Arun District Council
Arun Civic Centre
Maltravers Road
Littlehampton
West Sussex BN17 5LF
Planning & Building Control General Enquiries
Tel: (01903) 737756 Fax: (01903) 730442
Dx: 57406 Littlehampton
Minicom: 01903 732765
e-mail: planning@arun.gov.uk
website: www.arun.gov.uk/planning

8th March 2022

Application No: AB/4/22/L
Site Address: Mews House London Road Arundel BN18 9BH
Description of works: Listed building consent for the conversion of loft to habitable use including installation of 3 x dormers and roof terrace, addition of rendering, and alterations to fenestration/openings.

EAST ELEVATION PROPOSED

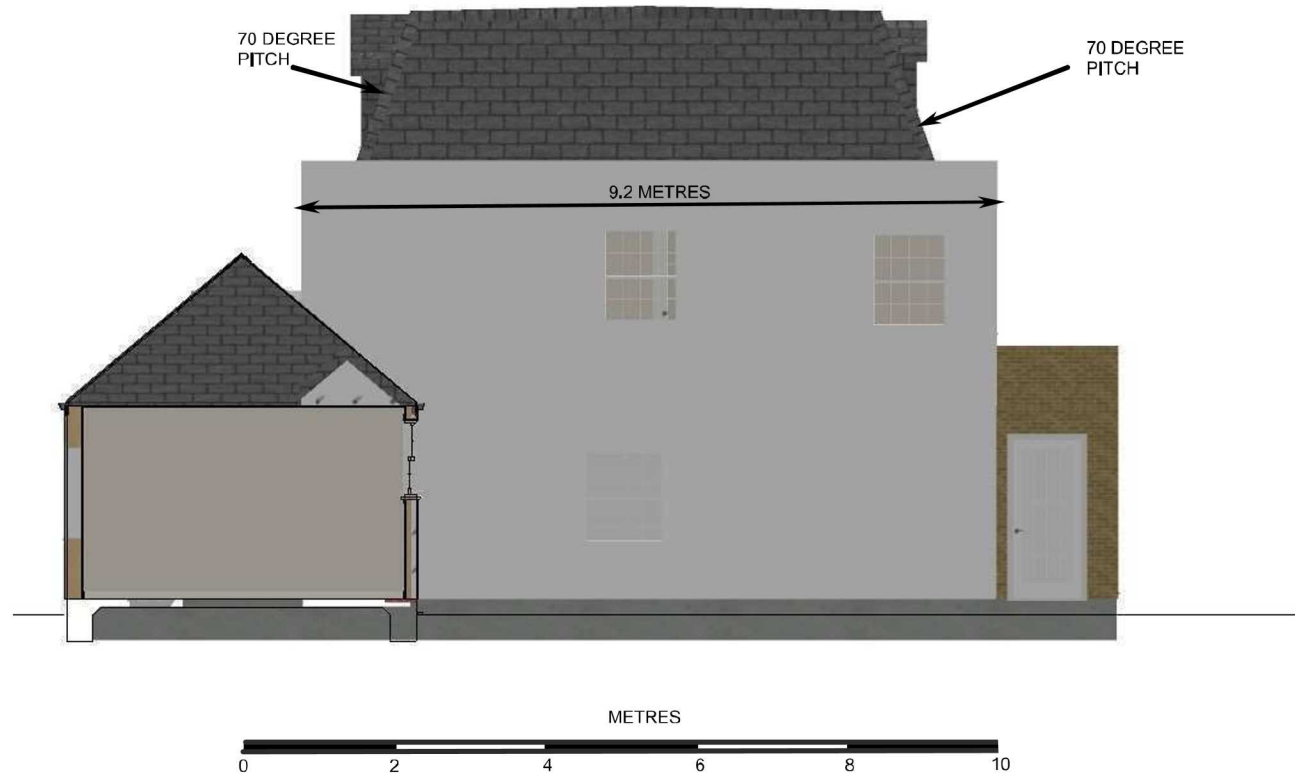
The Committee objected to the Application because the property is in a prominent position in the town and although the roof alterations may be sympathetic to the street scene, the submitted plans do not give a great deal of detail into the proposals. The glass roof terrace will be in a very prominent position. The current existing roof terrace is at the rear of the building and less conspicuous. Councillors feel very strongly that this application should not proceed.

The proposed development, by virtue of its unsympathetic design and prominent location is considered to have an unacceptable and incongruous impact upon the character and appearance of the host dwelling as well as that of the immediate locality contrary to policy HER DM1 of the Arun Local Plan. Also, the proposal involves harm to the Grade II Listed Building, the setting of nearby heritage assets, and the Conservation Area. Therefore, the proposal conflicts with policies HER DM1 and HER DM3 of the Arun District Local Plan. It also fails the public benefit test, as set out in Paragraph 196 of the National Planning Policy Framework.
